Application No: EP/126/20/HH
Site Address: 56 Angmering Lane East Preston BN16 2TA
Description of works: Resubmission (EP/37/20/HH) of proposed extensive refurbishment of existing 2-storey dwelling to include, single storey side/rear extensions, 2-storey rear extension, roof extension and front double garage

Thank you for your internet representation made on 2nd December 2020 which has been recorded as an objection with the comments as follows:

PROPOSED EAST ELEVATION 1:50

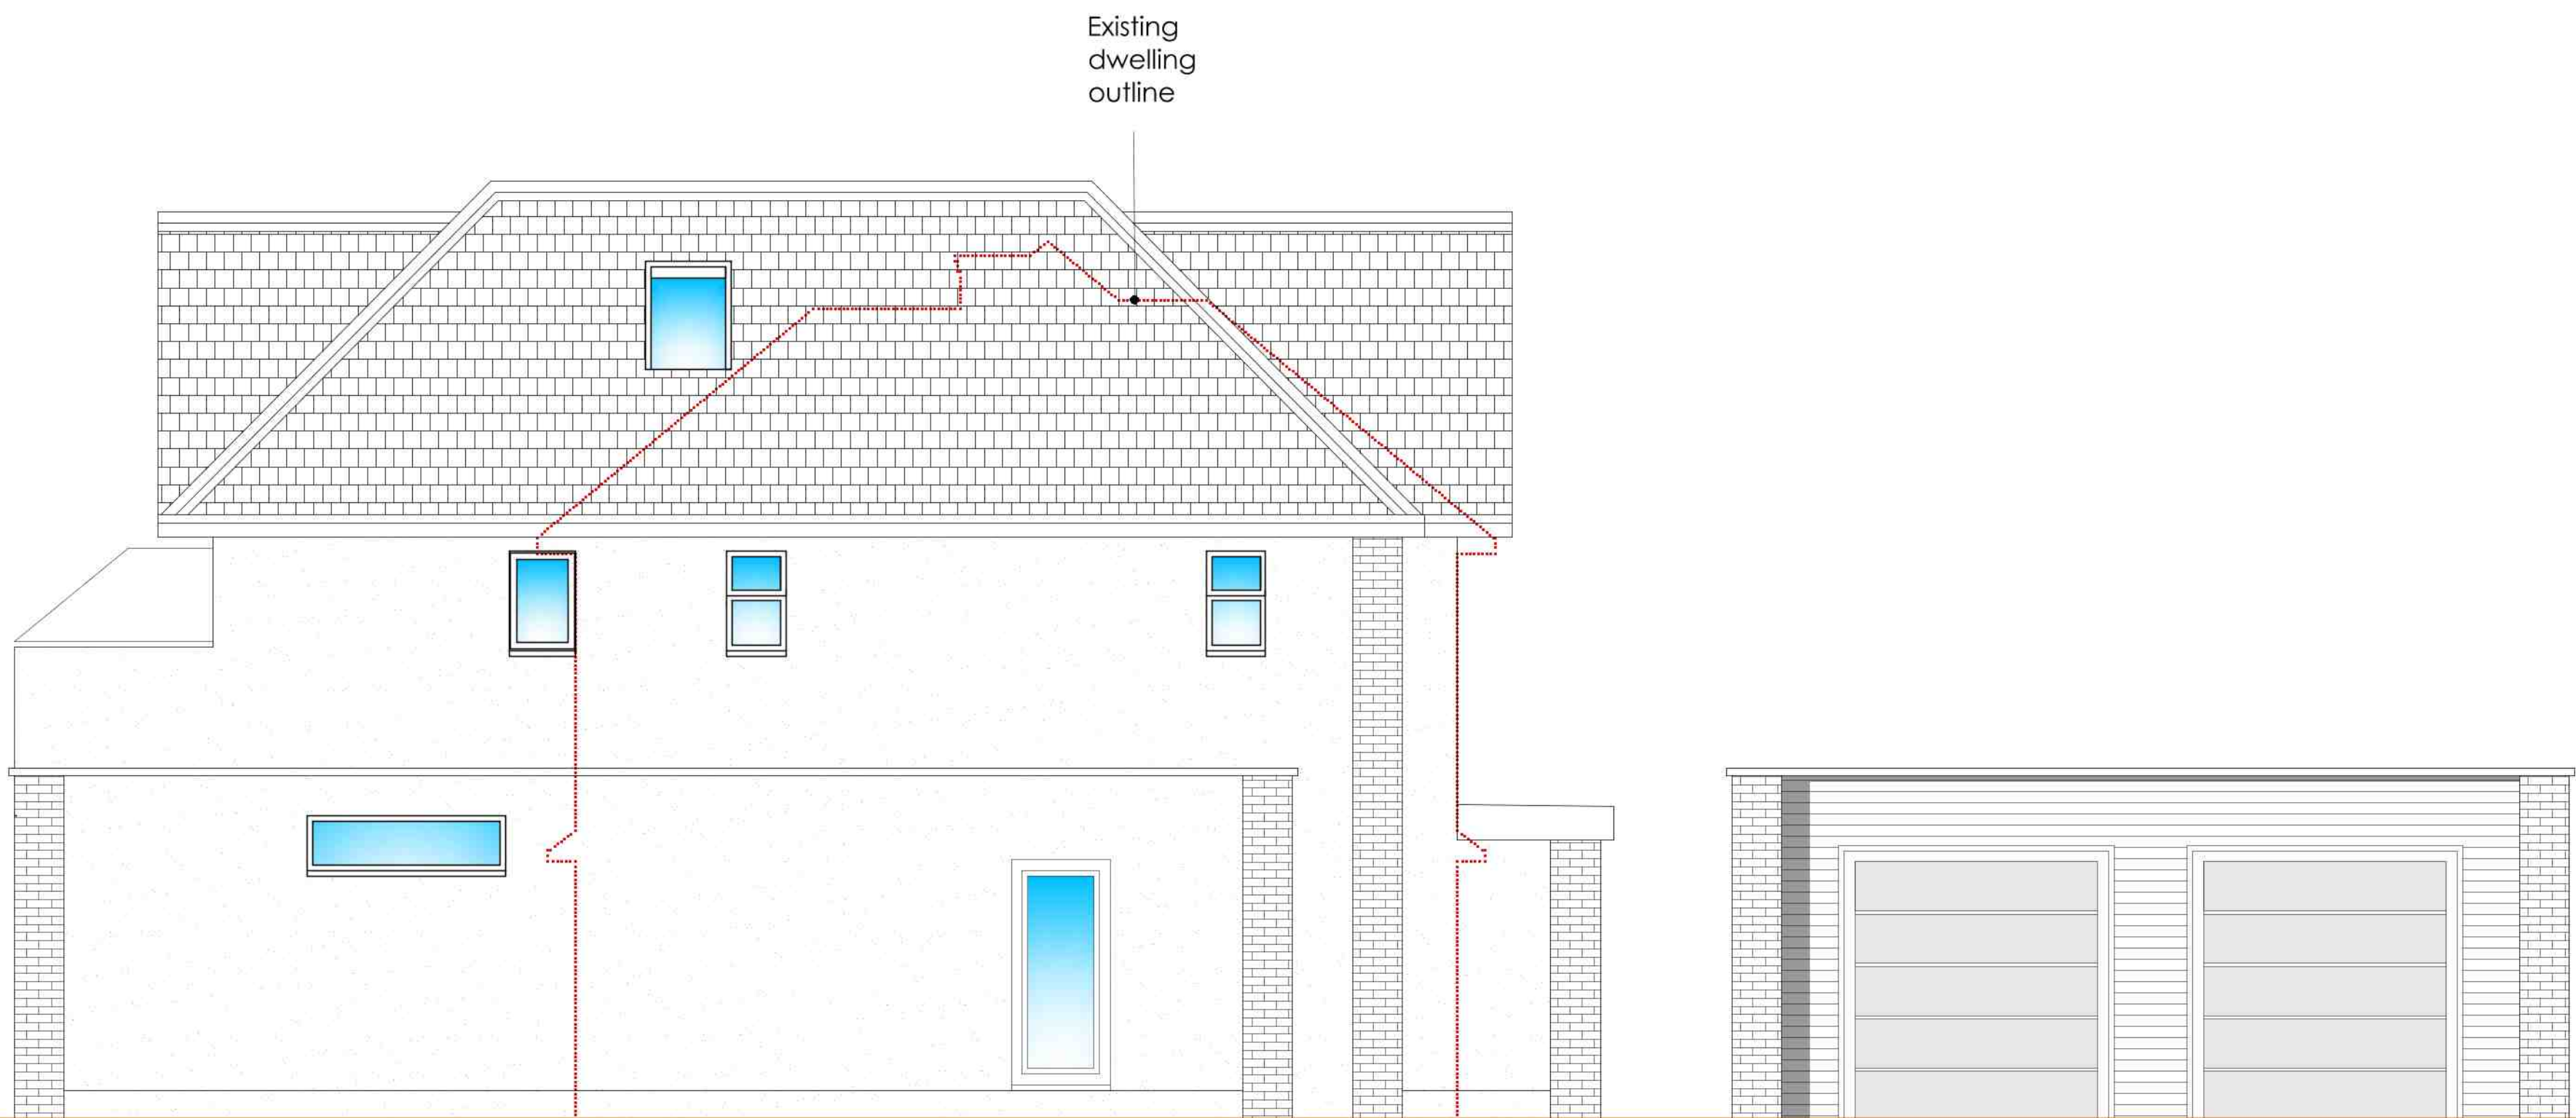
The proposed triple paned floor to eaves east facing window at roof level would be intrusive - having an invasive overview of a large part of our rear garden, our conservatory which is integral to our house and in daily use, together with the balcony and patio doors of our main bedroom. There is no mention of obscured glass, which would have the mutually beneficial effect of giving privacy to both us and the inhabitants of number 56.

It is unclear to us from the plans whether the windows on the northern elevation are of obscured glass. We would request that they should be.
